City of Albuquerque Stormwater Construction Site Inspection Report

Project Name:	Top Golf				
Location:	1600 Desert Surf				
Site Contact Name & Agency	Troy Manwill - Arco Murray	ESC File No.	F16E003E1		
	troymanwill@arcomurray.com	NPDES Id. No.	NMR100XF		
Inspection Date:	12/20/19	Start/End Time:	0835/0915		
CoA Stormwater Inspector:	Timothy E. Sims				
Construction Phase:	vertical				
Type of Inspection:	<input checked="" type="checkbox"/> Regular	<input type="checkbox"/> Storm Event	<input type="checkbox"/> Post Storm Event >0.25"	<input type="checkbox"/> 311/Complaint	<input type="checkbox"/> Follow Up

SEDIMENTATION/SILT FENCE WITH WIRE SUPPORT

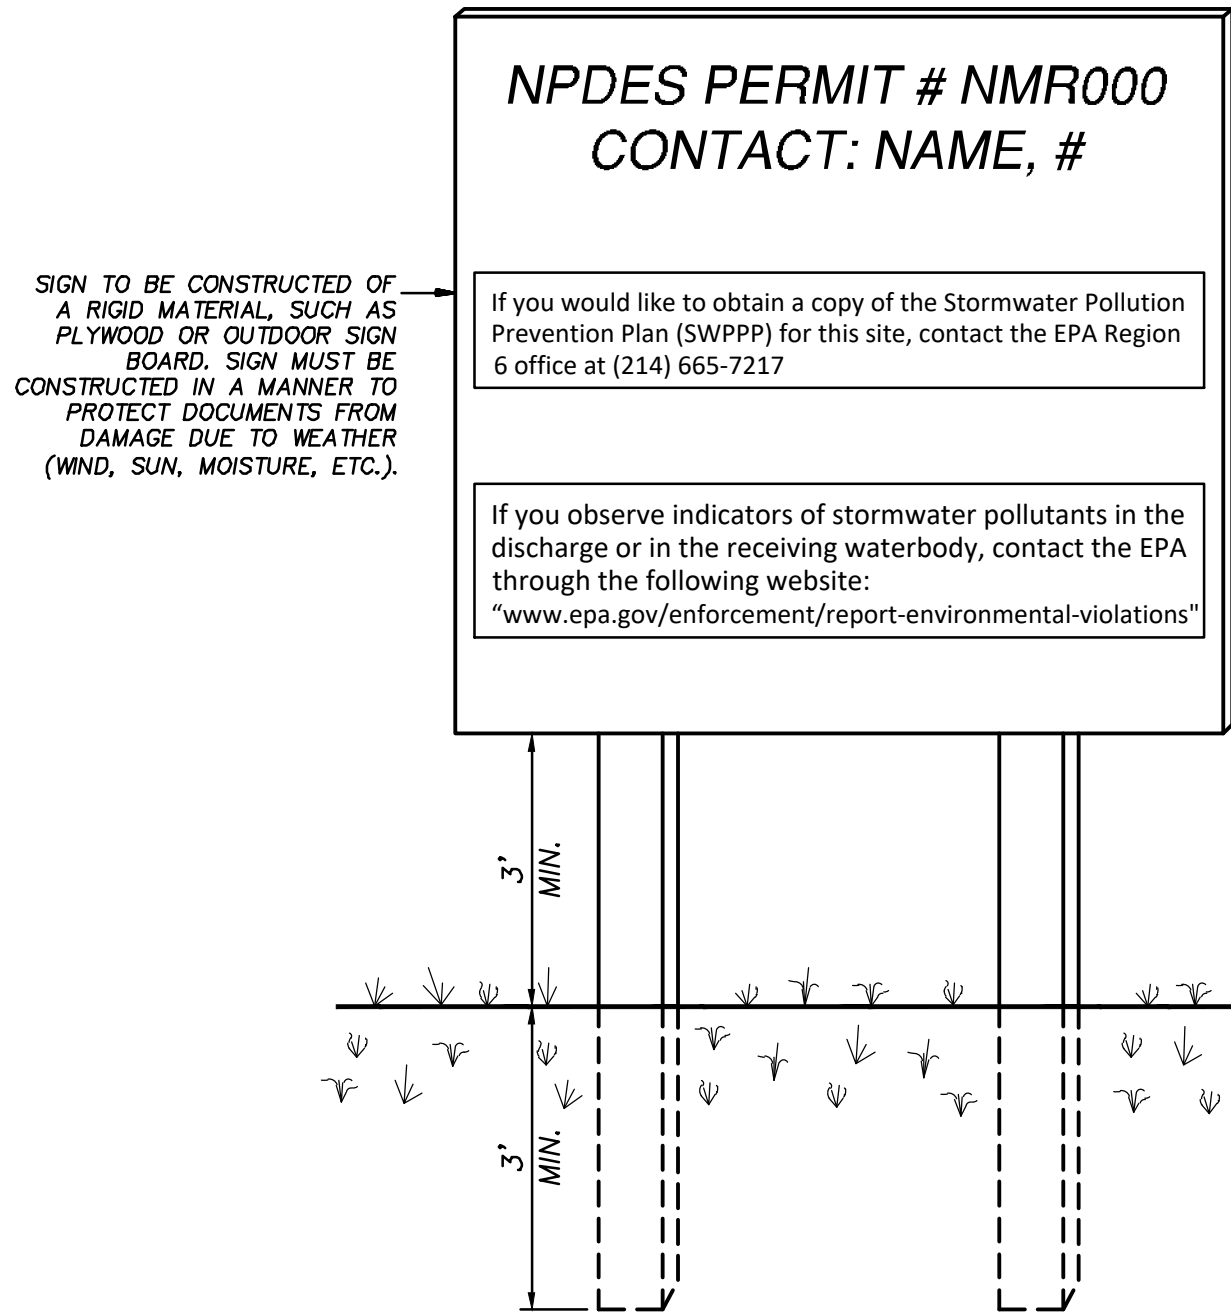
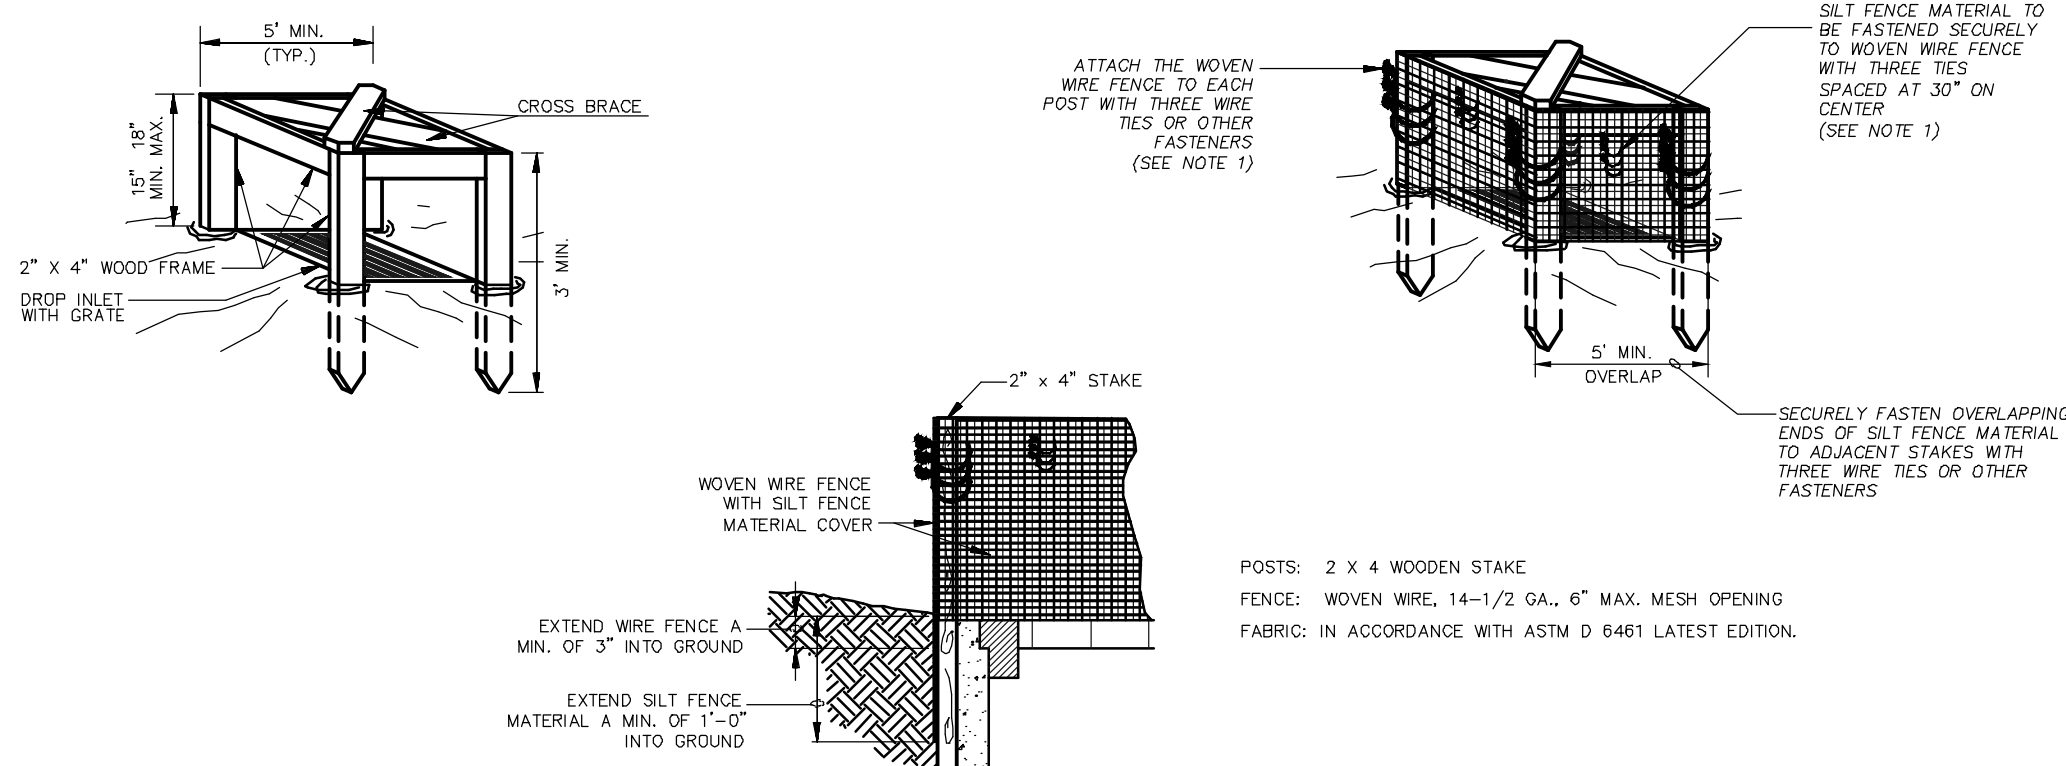
Item Number	Deficiency/ Corrective Action		
1	Sediment BMP needed for Pond lot.		
2	Northern most trackout pad requires mitigation.		
3	Restore silt fence where landscapers are working.		
2.1	Discharge off site? (Y/N)	No	
4	Self Inspection Reports		Latest report Date: 12/19/2019
